FROM: Ian Gledhill TO: Arun District Council
FAO: Michael Eastham

SUBJECT: BE/102/17/OUT - Hybrid application comprising Outline application for development of employment units, warehouse, hotel, 2No. drive-thru units, public house, gym plus engineering works, landscaping & associated works. Full application for a Warehouse (class B8), fuel island, car parking, access roads with new entrance from Shripney Road plus engineering works, open space, landscaping & associated works. Departure from the Development Plan.

Salt Box Field Land Off, Rowan Way, Bersted, PO22 9NW

APPENDIX 9.2
SITE ACCESS ARRANGEMENTS

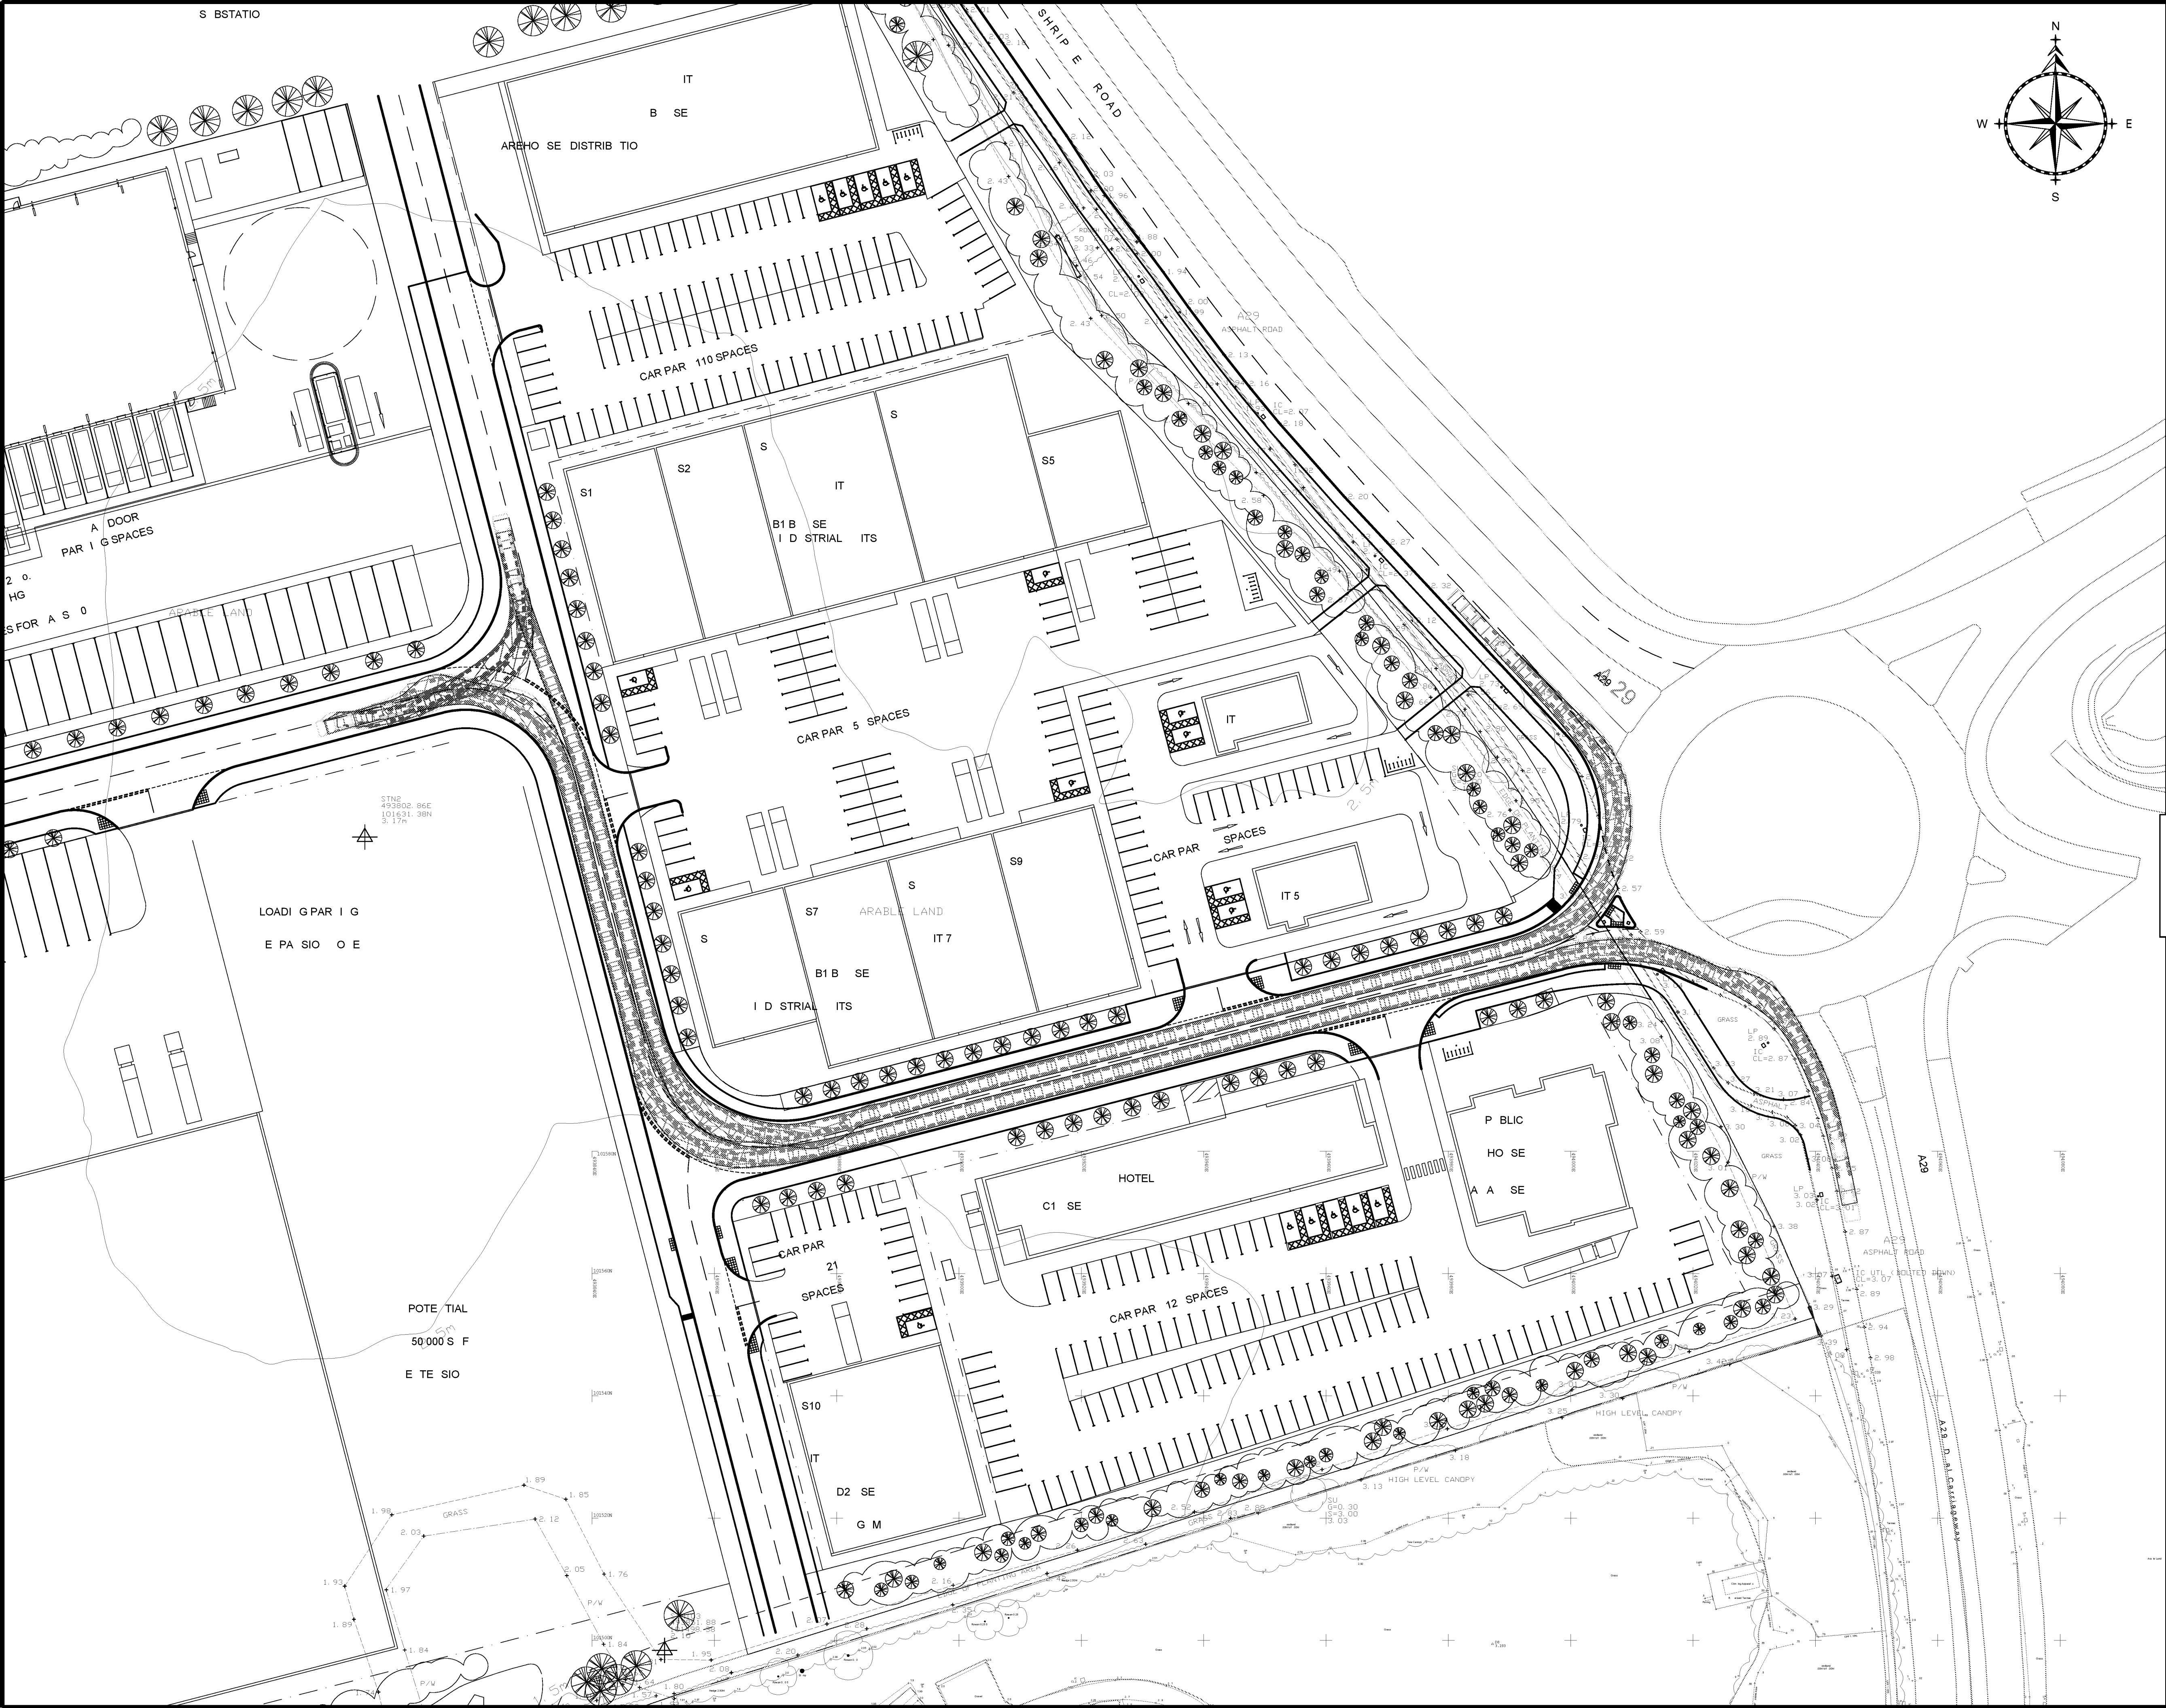
5. The LDO Stage One RSA raises a number of problems, only one relates to the proposed access. Although the Designers Response to this problem (the location of the pedestrian crossing over the new roundabout arm) doesn't fully address the issue as stated by the Auditor, the solution as shown on the unnumbered plan in appendix 9.2 of the TA is considered acceptable.
